Planning Application Response

Organisation:	Barnsley Council
Detail:	Re-engineering and restoration of Yew Tree Quarry through the importation of non-hazardous excavated soil materials – Stairfoot Brickworks, Wombwell Lane
Planning Ref:	2025/0908
Link:	Application Details
Closing Date:	30 th March 2026

Response to:	developmentmanagement@barnsley.gov.uk / helenwillows@barnsley.gov.uk
Submitted by	Trans Pennine Trail National Office & Walk Wheel Cycle Trust
Date:	30 th March 2026
<p>The Trans Pennine Trail National Office (TPT) and the Walk Wheel Cycle Trust (formerly Sustrans) (NCN) welcome the opportunity to respond further to this planning application, in relation to the documents you state:</p> <p>A – Amended Proposed Site Access Arrangements – 12th March B – Application Boundary – 10th February C – Delivery Management Plan – 12th March</p> <p>The map below shows the development location and alignment of TPT/NCN:</p> <p>Yellow: TPT/NCN Red: Current Application Blue: 2022/ENQ/00353 - Restoration and aftercare scheme, Stairfoot Quarry (which also includes the current application area)</p>

VIEWPORT 3 - SWEEP PATH ANALYSIS (SCALE 1:1000@A1)

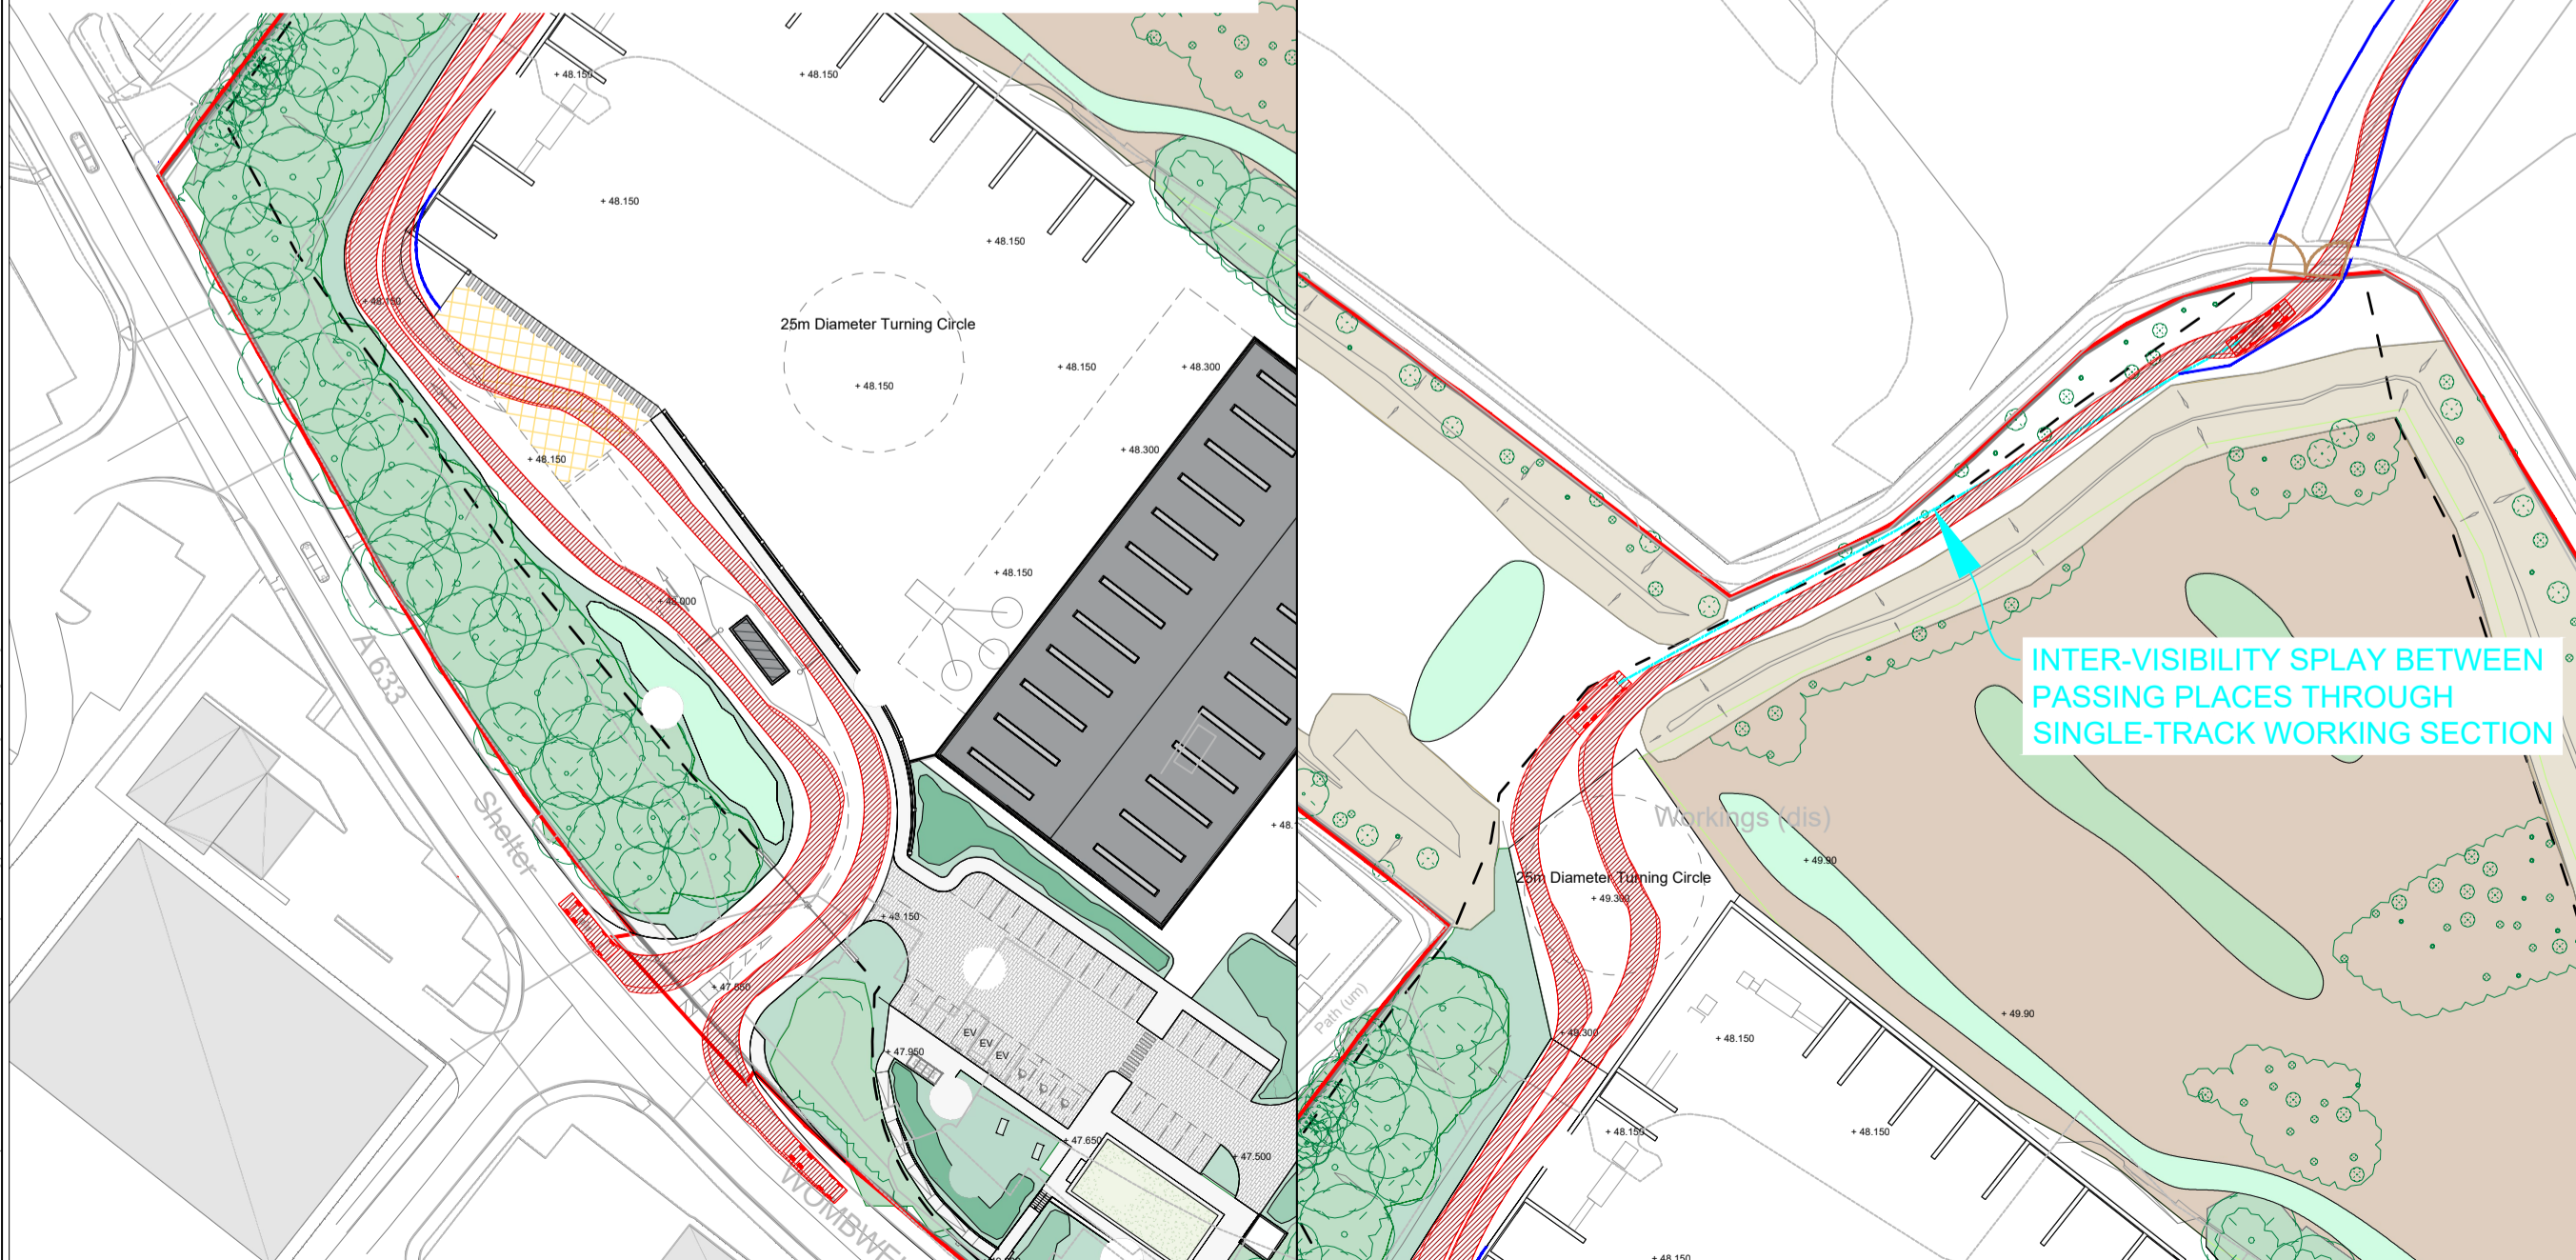
Is this the location of the security office/vehicle check-in? If so, please label on plan:

3.4.1	Notes security gate that drivers should report into – this isn’t clearly shown on the Site Access Arrangement Plan provided.
3.4.2	The commitment for a banksman to be present at the RPWO crossing at all times during operating hours is noted and appreciated.
